Written representation Identification 20030110 from Alan Smith to Planning Inspectorate re application No EN 10106 Re Sunnica Ltd

Main WR Document dated 13th October 2022

Re Accompanied Site visit Inspection 2 (AS12) 2nd November 2022 (p.m). Worlington.

Drawing Title
**FIGURE 3-1
SUNNICA EAST
PARAMETER PLAN**

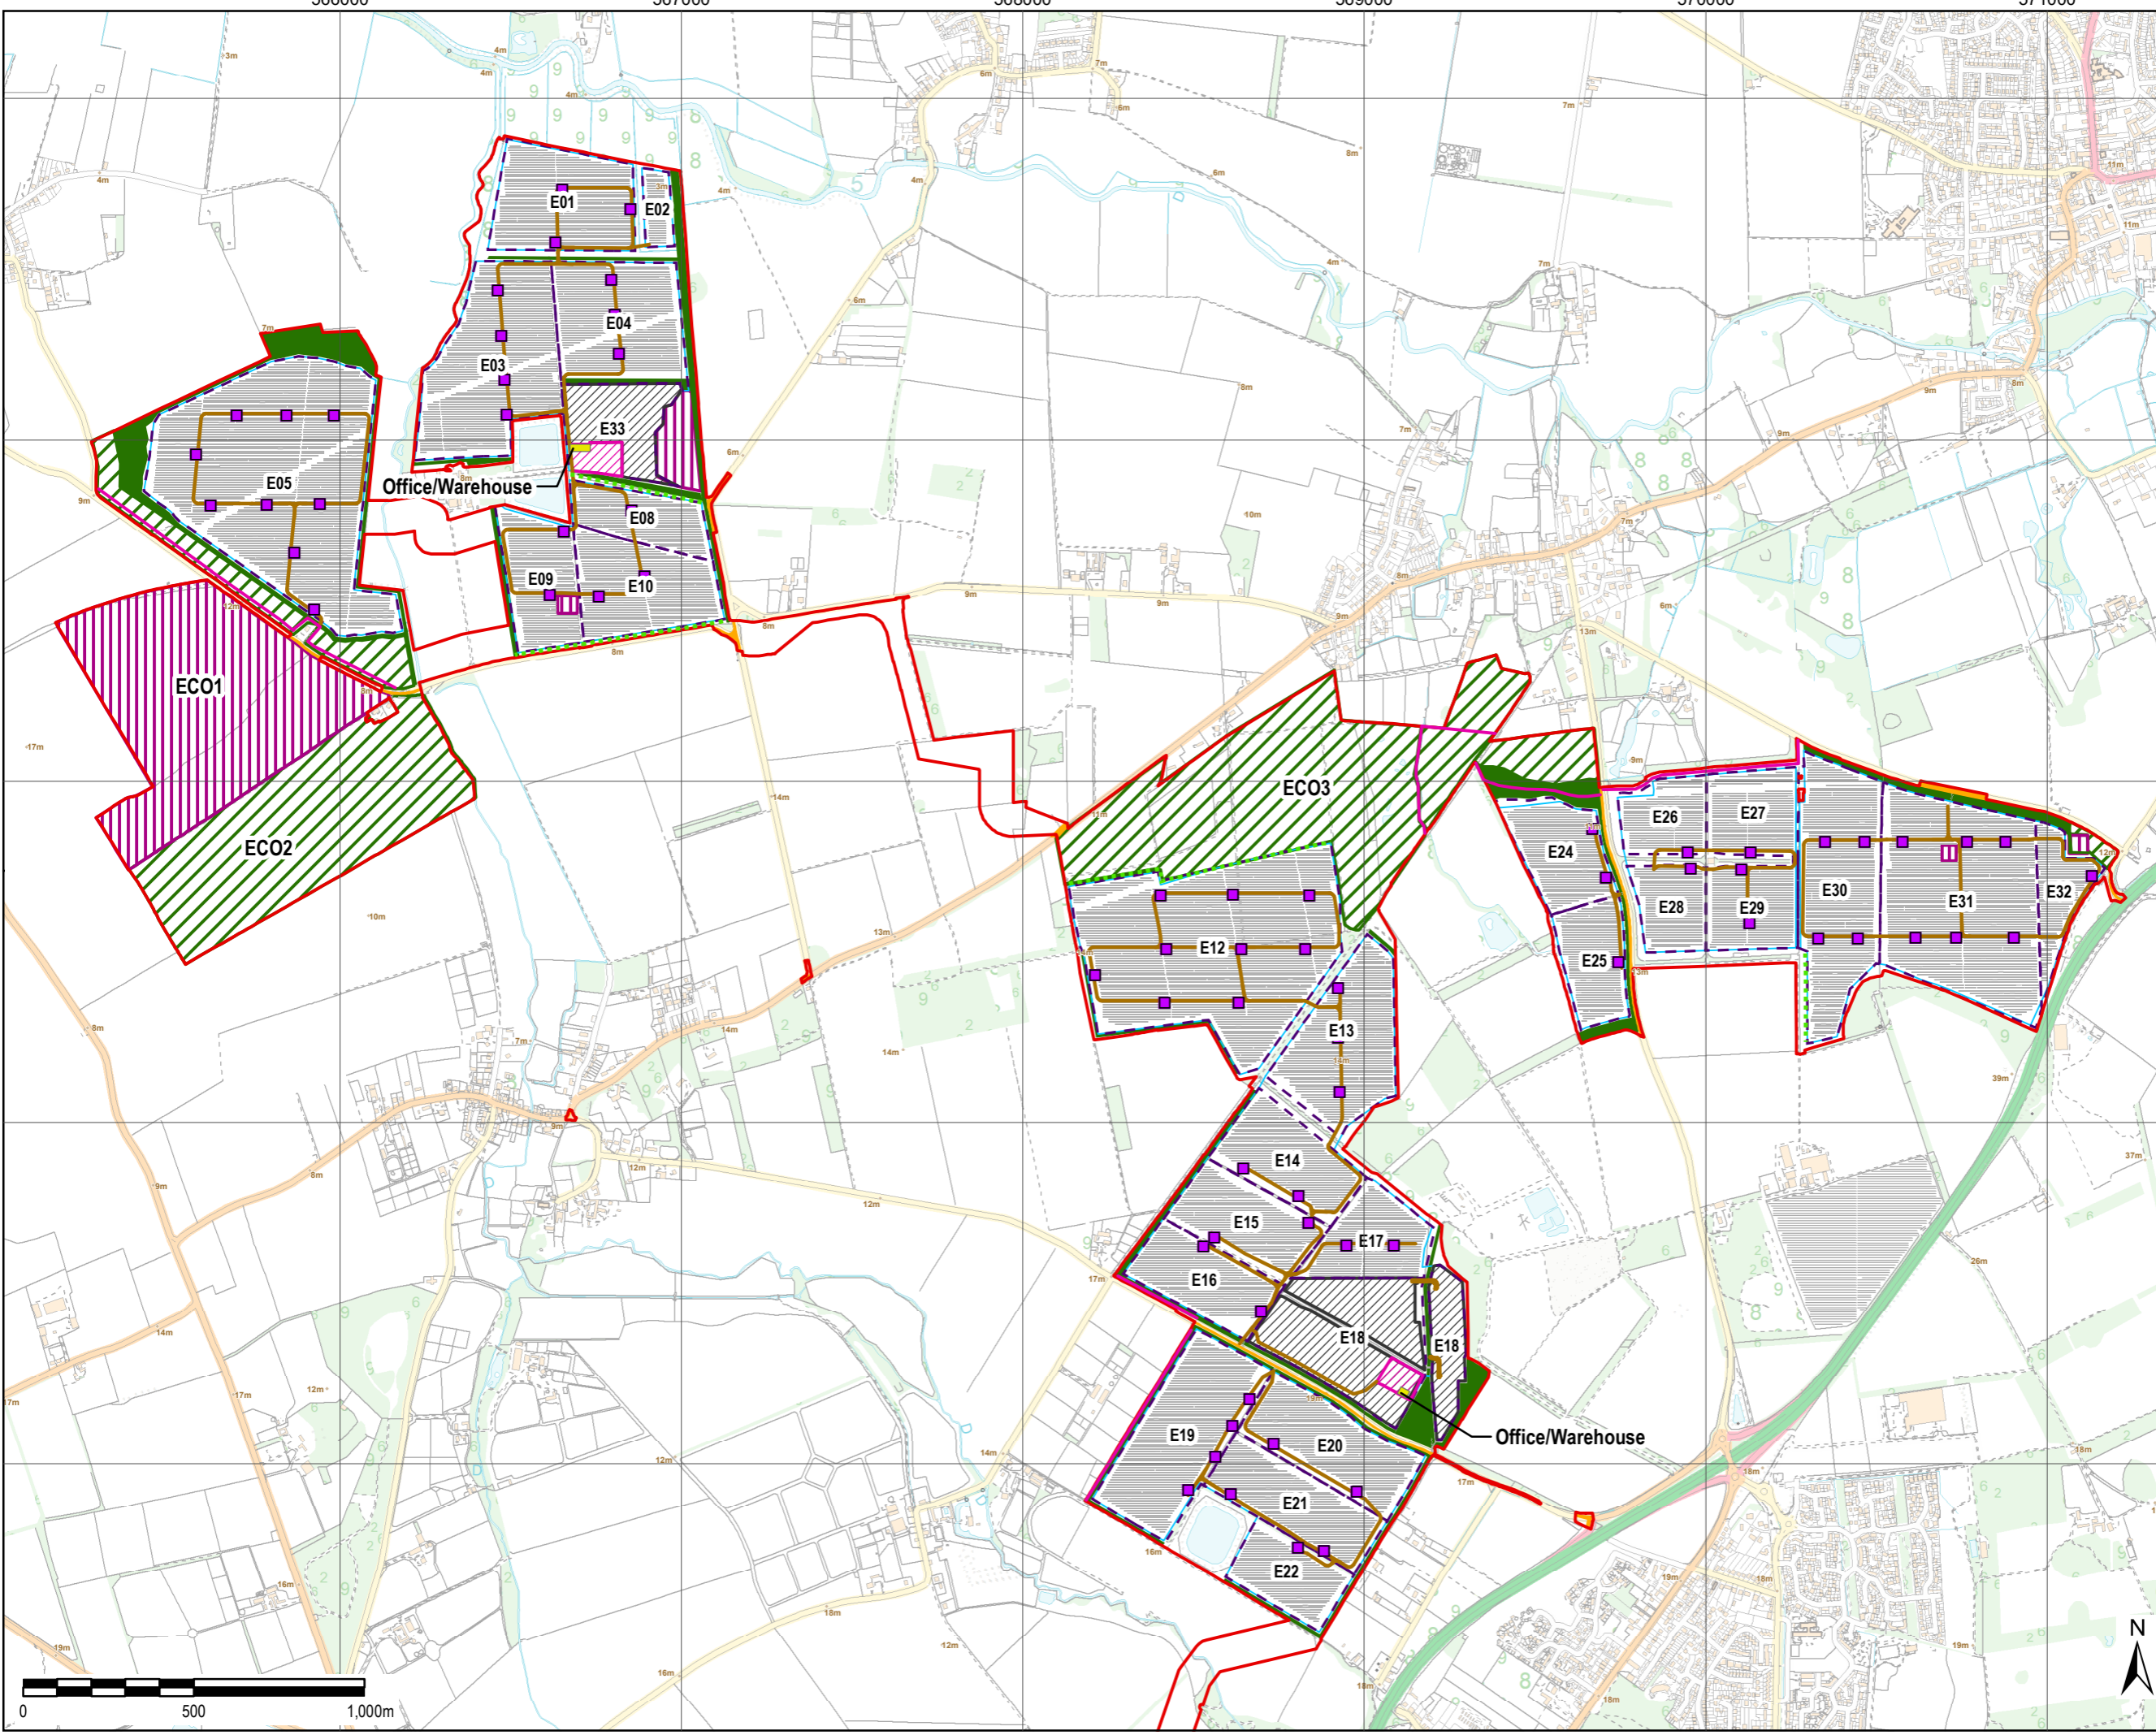
It was stated" that the distance between the proposed solar infrastructure at E12 on their plan and the closest properties at the Southern tip of Worlington is approximately 490 metres. There was confusion on site when Mr Murray (Director of Sunnica Ltd) indicated a point much closer to my property of 30 metres.

I have engaged an outside firm, Michelle Bolger Expert Landscape Consultancy, whose measurement from Fig 3.1 Sunnica East Parameter Plan from my dwelling and the closest panels in E12 is 500.31 metres.

This is far too close to the residential properties in [REDACTED]

Again referring to the walking inspection of E12 I request this entire area is removed from the Sunnica plan. The reason is its incline and the affect the 13ft high panels would have on the Brecks landscape. The existing views from my property and the other properties in [REDACTED], (the B1102) which at the moment overlook the Brecks would become part of an industrial landscape.

Furthermore the view from [REDACTED] and the public footpath would be visually impaired due to the rear of the 13 feet high solar panels facing to the North, which are black, the solar glass faces South, and would also include 6 feet high fencing of the entire perimeter of that parcel of land.

In addition the removal of E12 would enhance the value of PROW Number U6006 which is called Badlingham Lane/Icknield Way. . It is also noted from the plan that E12 is totally out of alignment with E13, E14, E15 and E16 and therefore E12 should be designated as an extension to ECO3.
